**RE: DFT Review Comments for Route 66 Flats (7600 Central Ave SW)**  
**Project Number: PR-2023-008589 aka (PR-2024-009904)**  
**Application Number: SI-2024-000136**

On behalf of High Desert Housing and BlueLine Development, thank you for your Site Plan review of the new affordable housing community located at 7600 Central Avenue SW.

Please see the attached comment responses to Plan Review #2, if there are any questions pertaining to the responses, please let us know- Thank you Taylor Bissert.

A4 ARCHITECTURAL SITE PLAN - SDP
 1" = 20'-0"

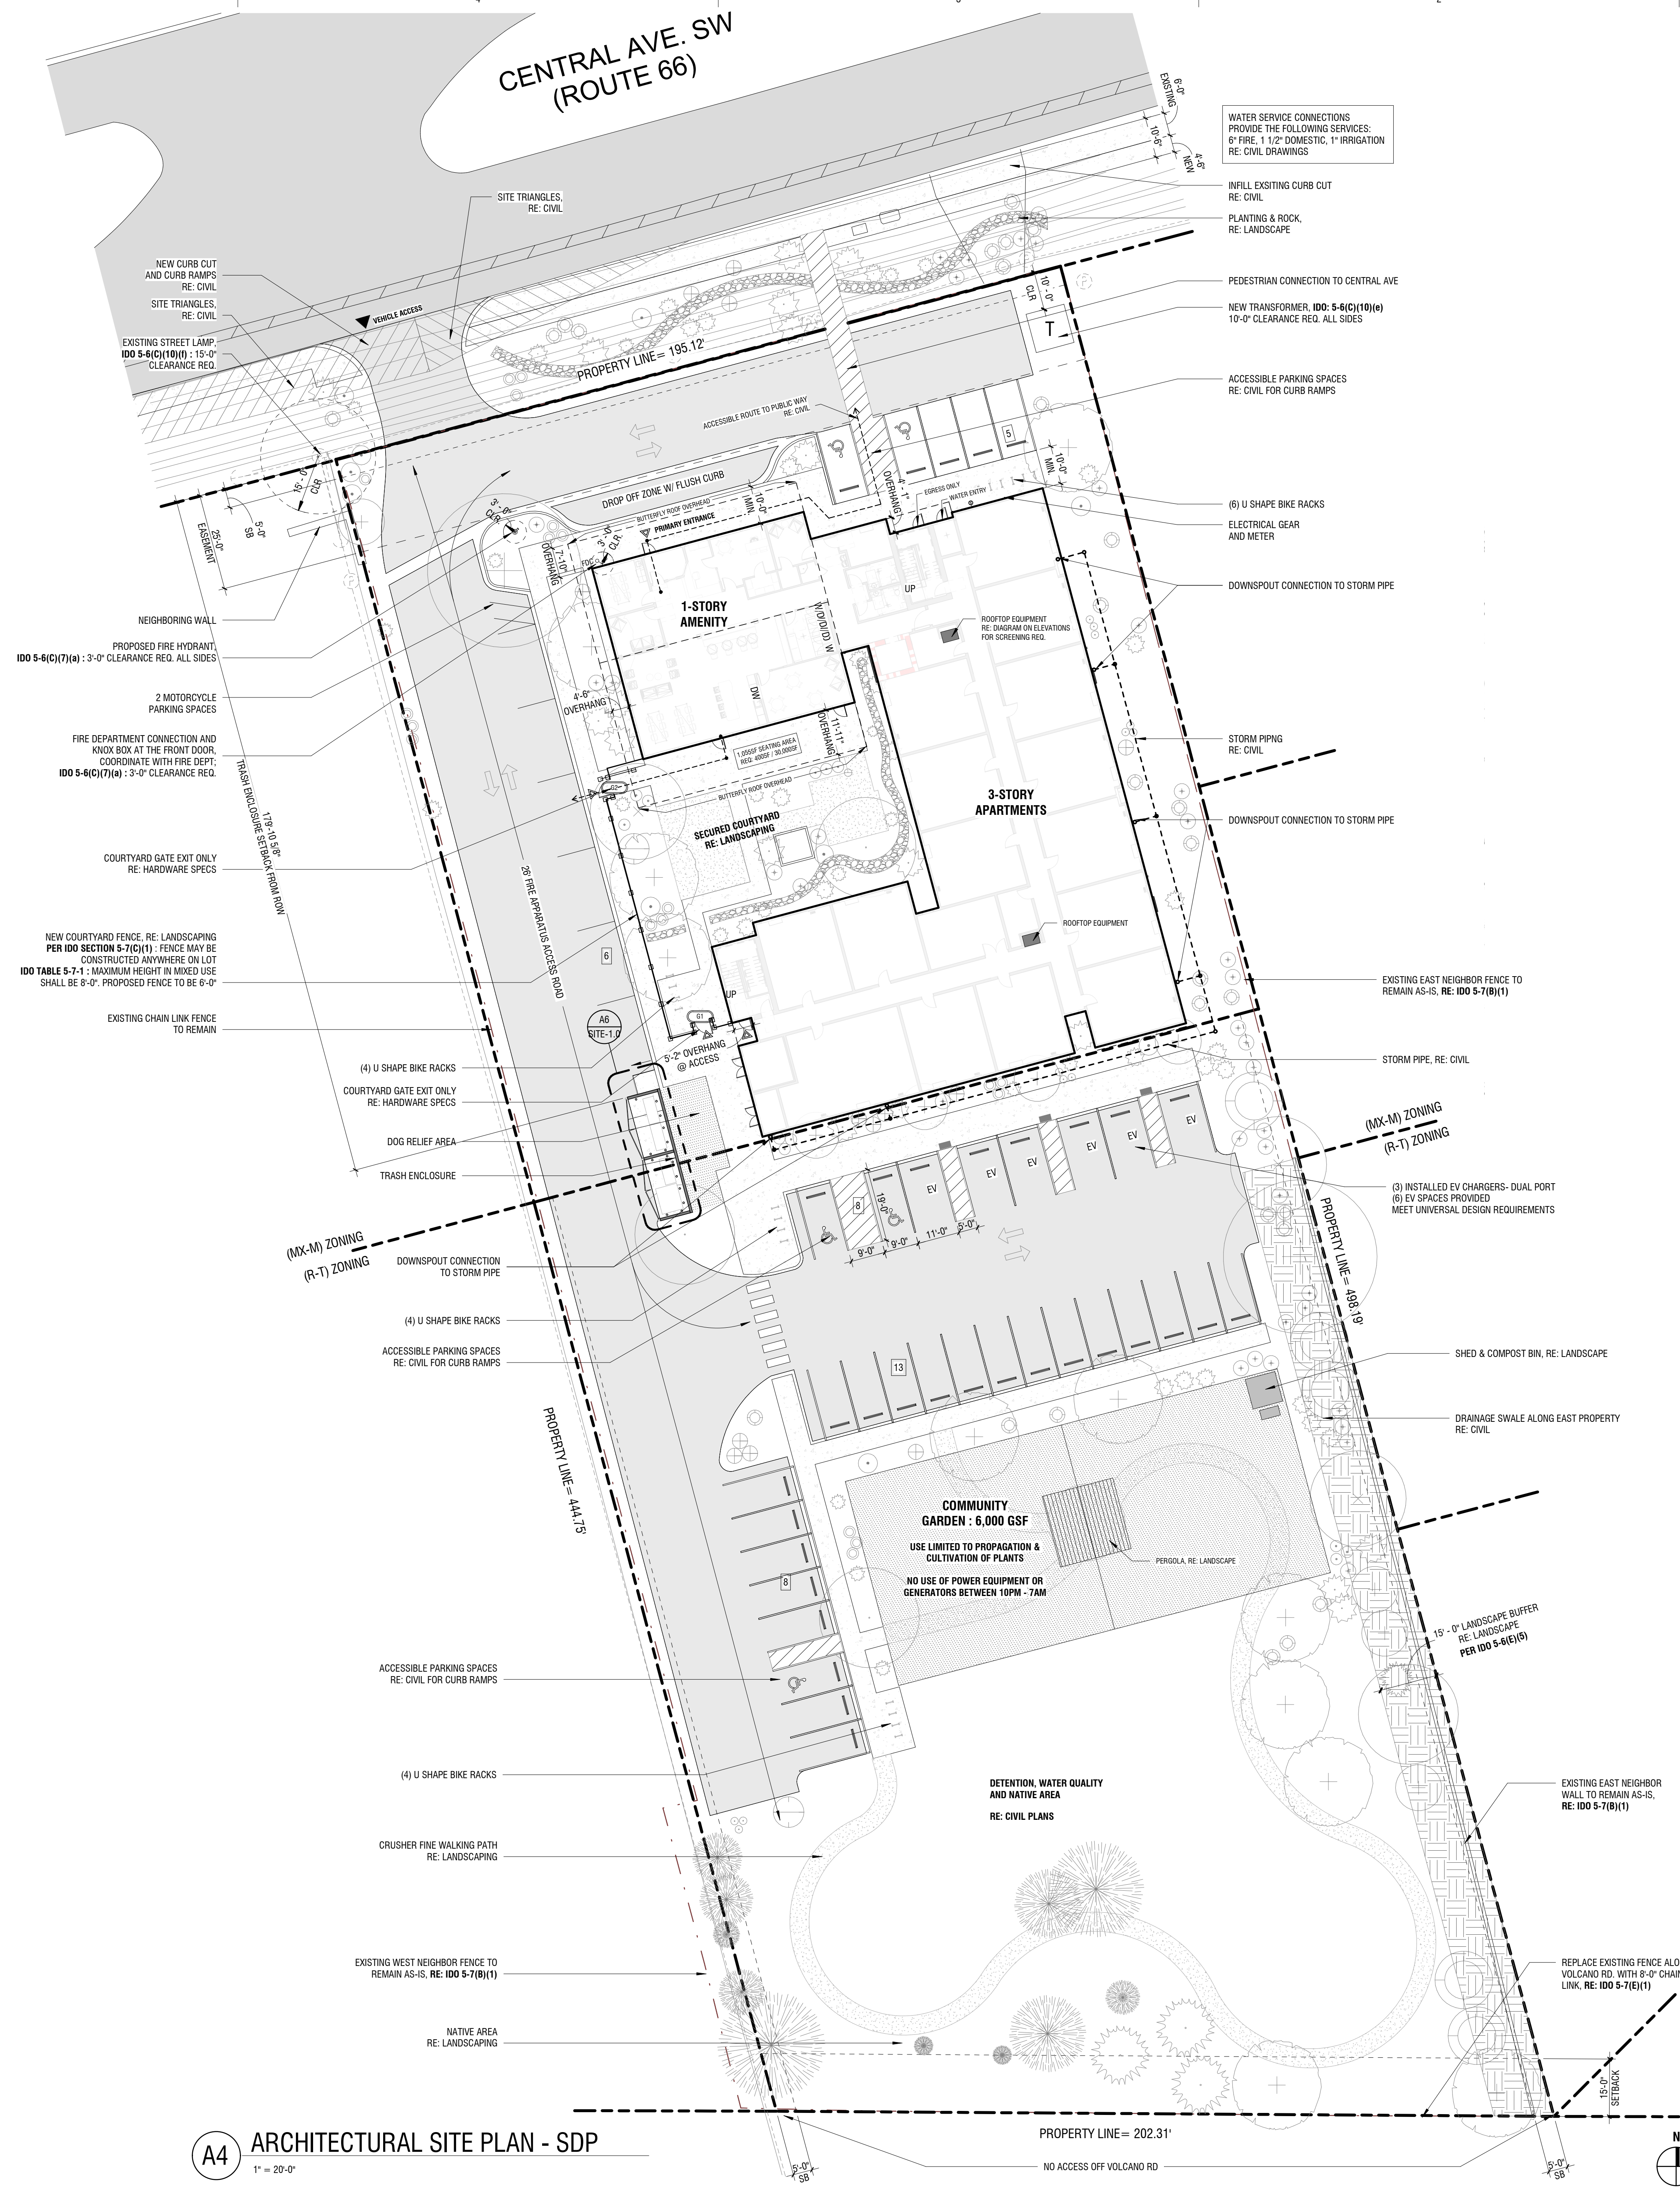
Operation of power equipment or generators shall not occur between the hours of 10:00 P.M. and 7:00 A.M.- **(SW Response) – note added to Architectural Site Plan on sheet SITE-1.0. “No use of power equipment or generators between 10pm – 7am”**

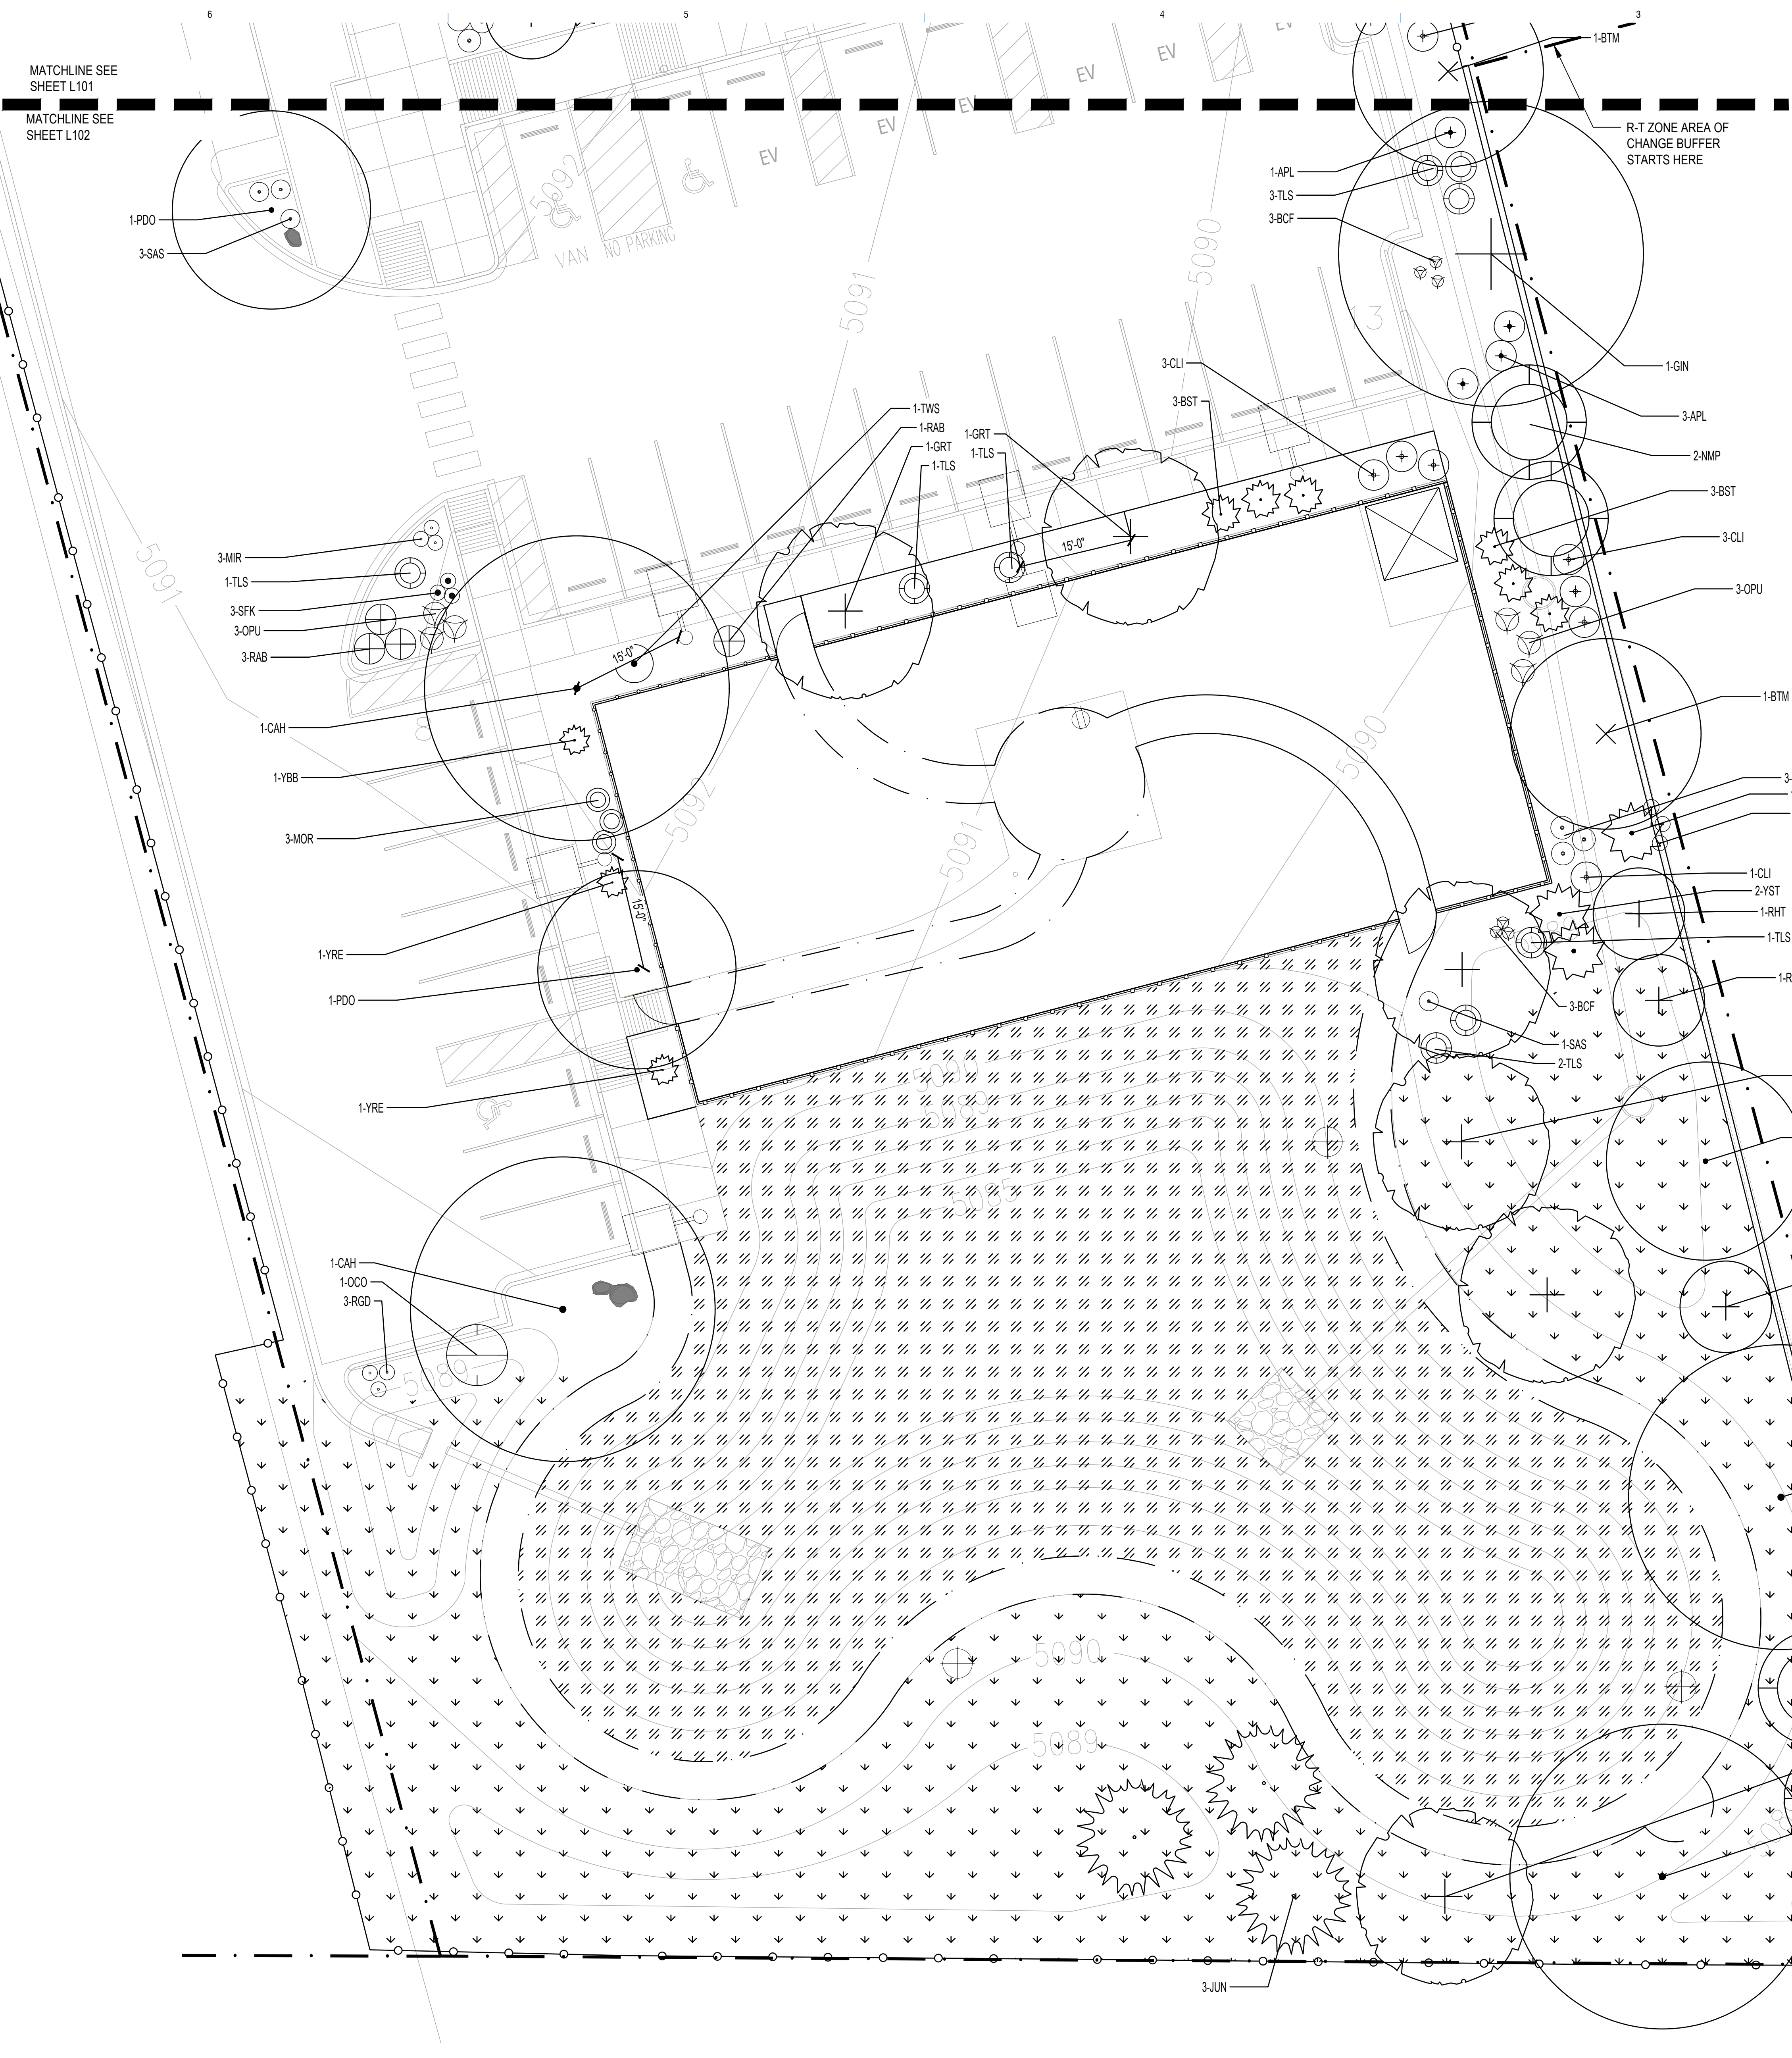
This use shall provide, somewhere on the lot, at least 1 tree per ground floor dwelling unit and at least 1 tree per second floor dwelling unit; no additional trees- **(Flow response) - Calculations updated and reflected in Alternative Landscape Plan**

Twenty-five (25) percent of the net lot area shall contain landscaping- **(Flow response) - Calculations updated and reflected in Alternative Landscape Plan**

The mature realistic spread of trees and shrubs will be used to calculate required vegetative coverage as follows. (SEE CALCS IN COMMENTS) ***(Flow Response) - Calculations updated and reflected in Alternative Landscape Plan. Calculations of individual species have been added to Plant Schedule.***

The use of gravel or crusher fines as ground cover is limited to a maximum of 75 percent of any landscaped area. ***(Flow Response) - Calculations updated and reflected in Alternative Landscape Plan. Area calculations have been added to landscape legend.***

Trees and shrubs shall not be planted in utility easements unless there is no other practicable location on the lot where the landscaping would achieve its intended purpose. The Planning Director may adjust the location of required landscaping to avoid utility easements, provided that the total amount of landscaping and buffering required is not reduced. ***(Flow Response) - Alternative Landscape Plan provided to address inability to provide street trees in utility easements.***

Per 5-6(C)(10)(b), trees shall not be planted within 10 feet in any direction of the centerline of a sewer or water line. (See figure below.) ***(Flow Response) - Alternative Landscape Plan provided to address inability to provide street trees in utility easements***
